March 5, 1979

Re: Terilynne Terrace Drainage Report

Re: Drainage Report for Terilynne Subdivision

GRADING PLAN

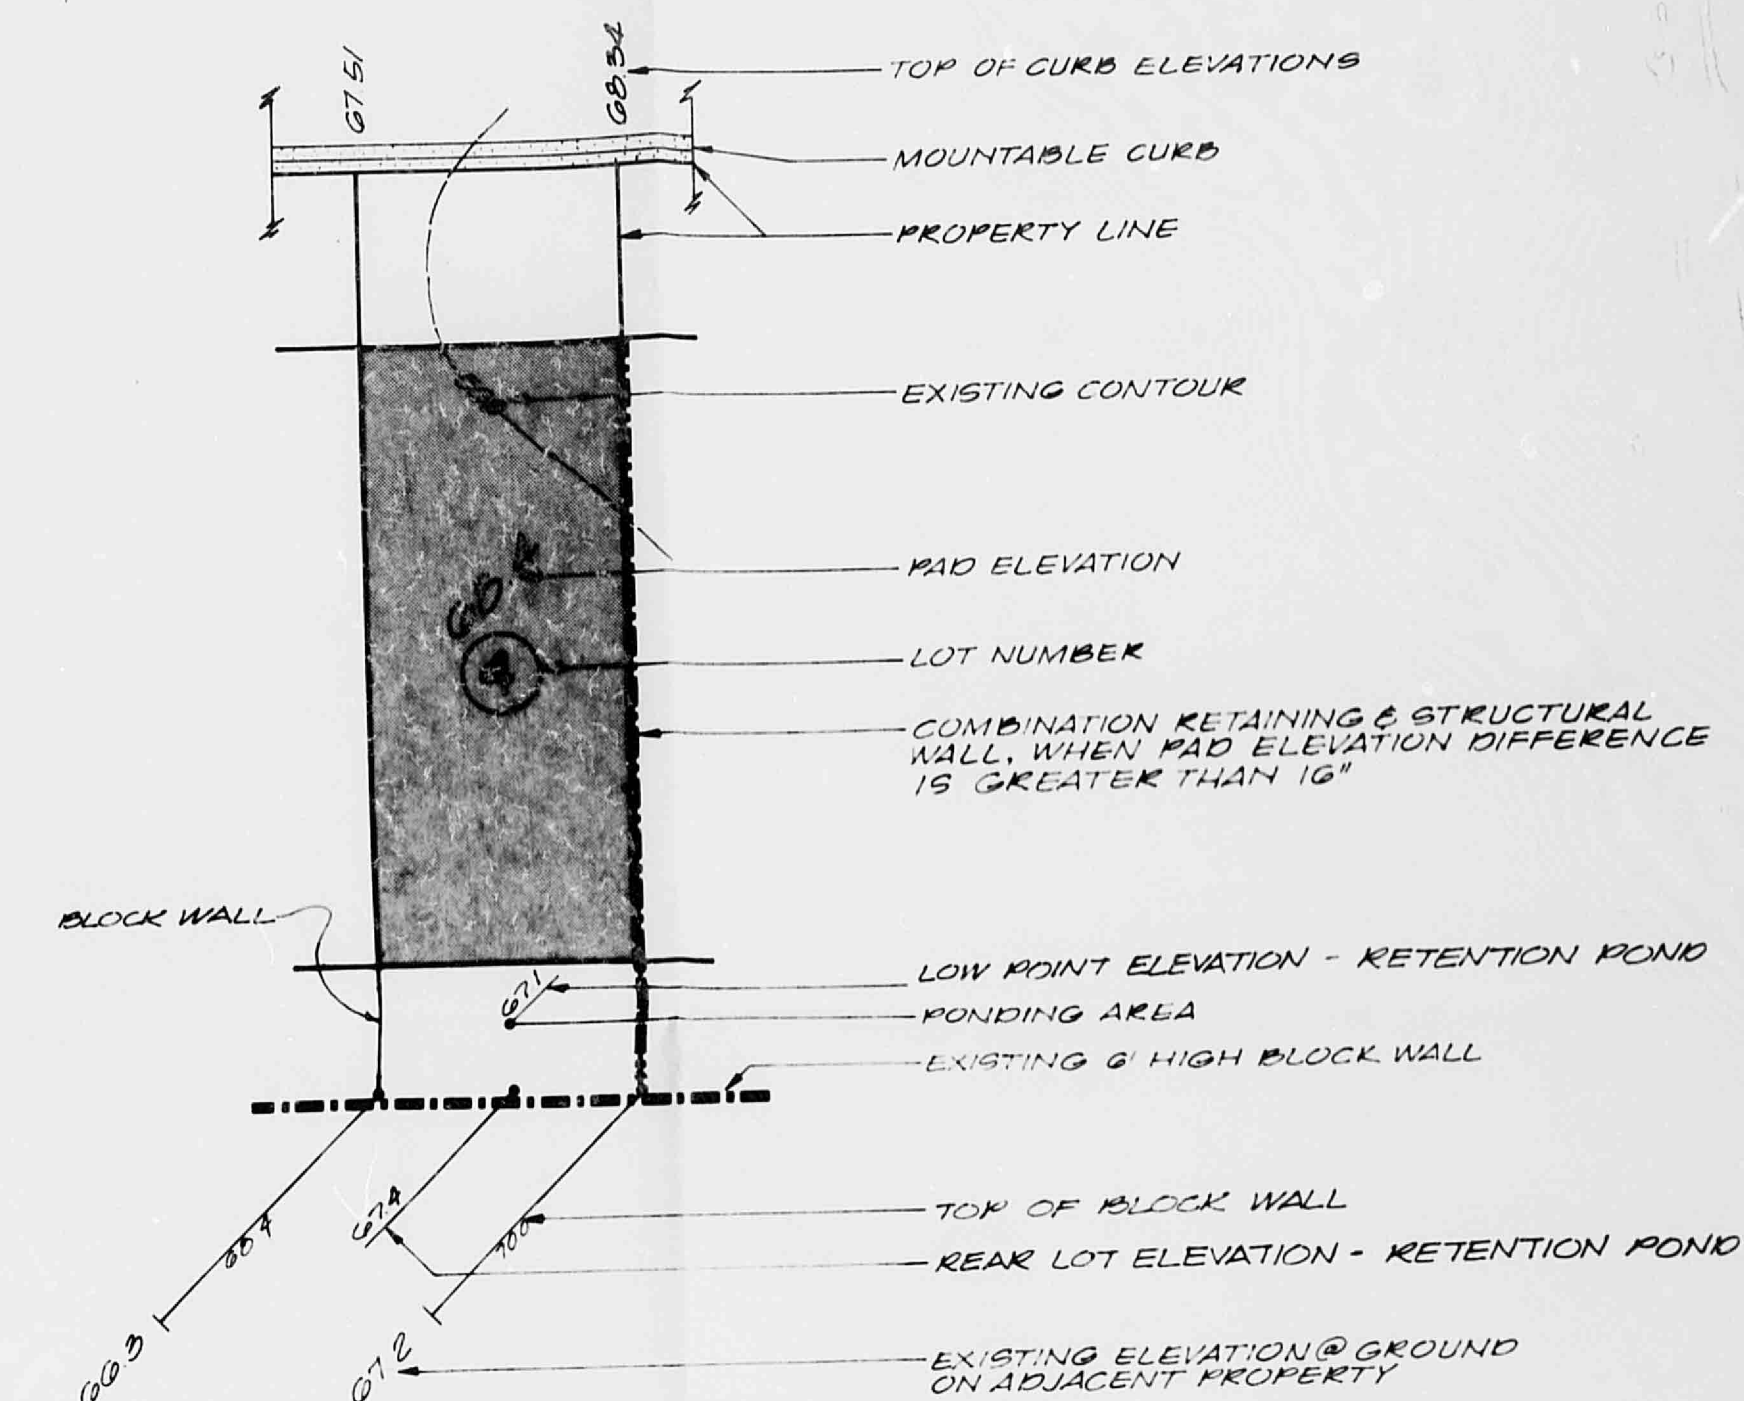
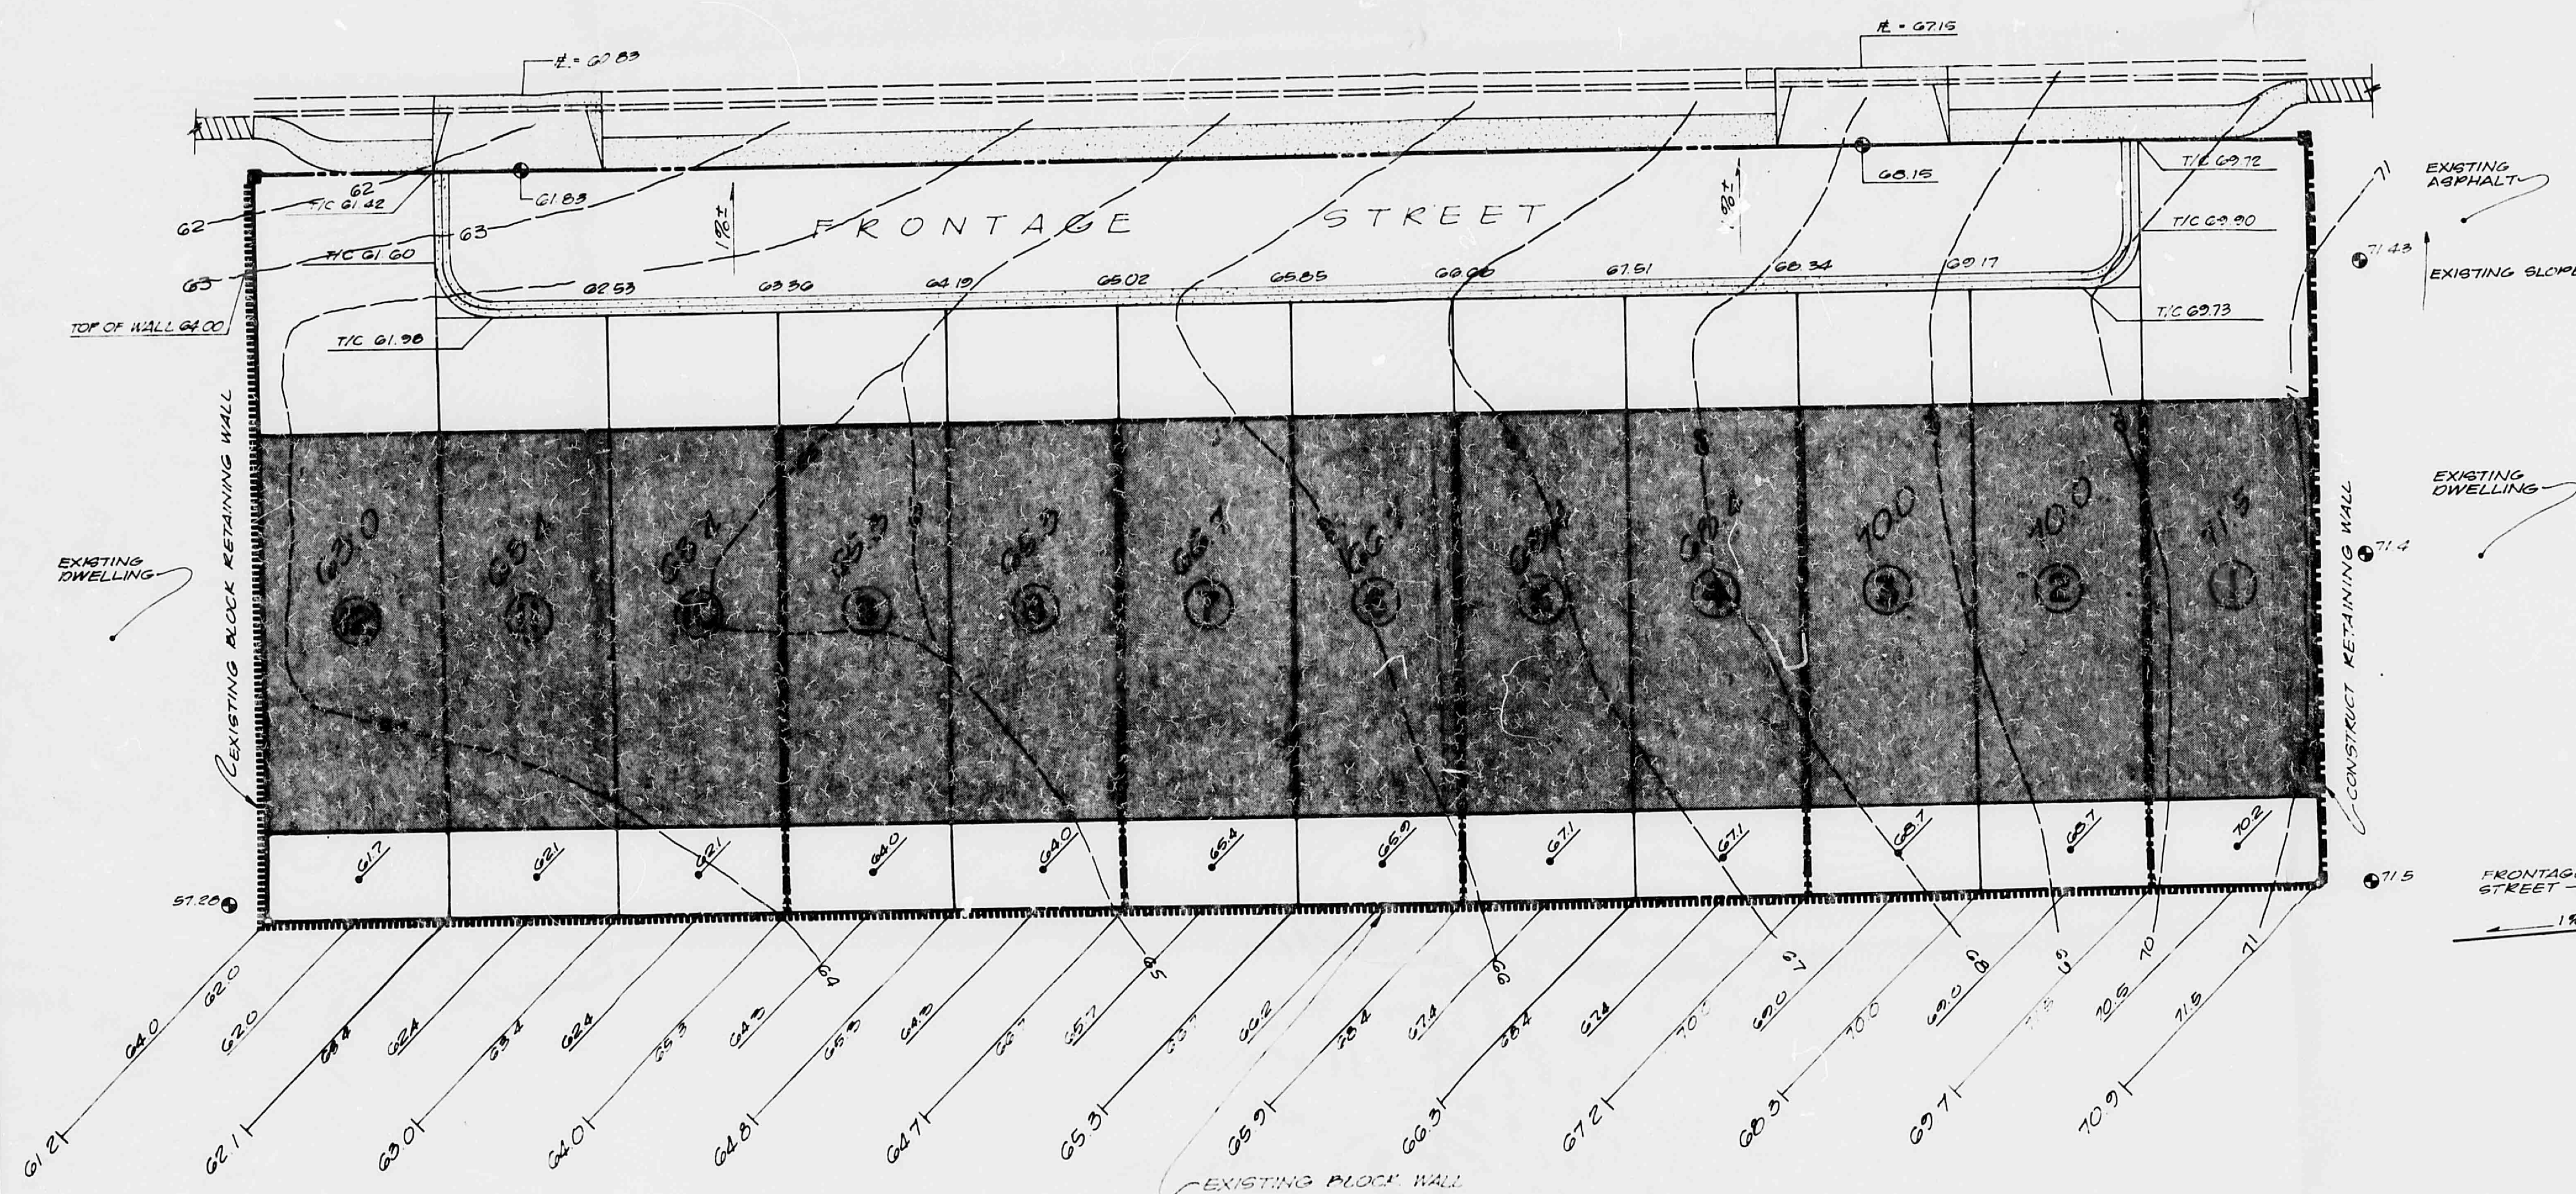
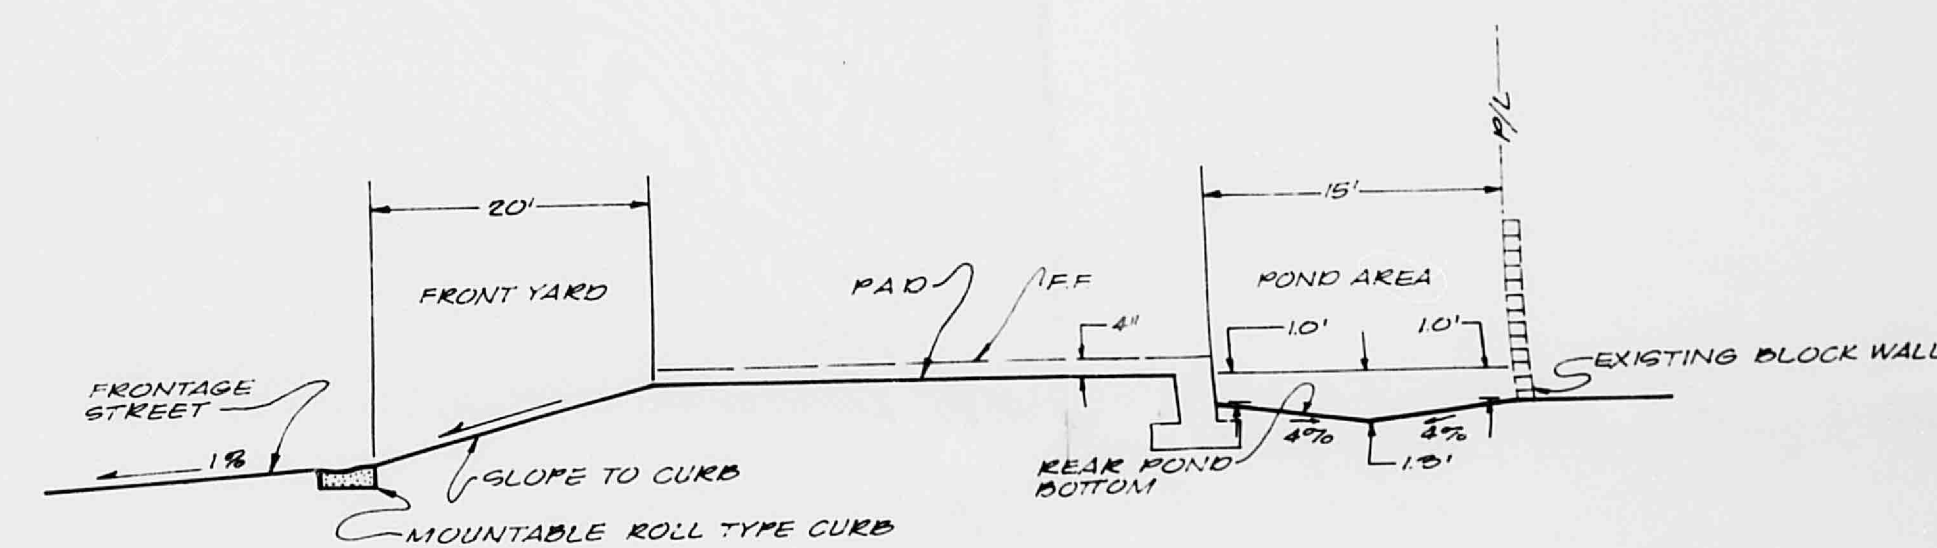
The grading plan also indicates that the runoff from the roof will accumulate against the garden wall to the south. What provisions will be made to prevent damages to the foundation and to the wall? The drainage report shows a detail of how the back yard ponding is supposed to be constructed. The same detail should be shown on the grading plan. I note also the ponding volume for the back yard ponds is computed using the procedure that makes allowance for the undeveloped runoff to exit the property. Since there is no way for the excess water to leave the property, the volume of the ponds must be adequate to handle 100% of the roof runoff.

With rear yards as some as these, water has to be ponded against the walls and foundations. Therefore, a note has been added to our drawings requiring the walls and foundations to be water proofed. Pond volumes have been increased to exceed a 100 percent retention.
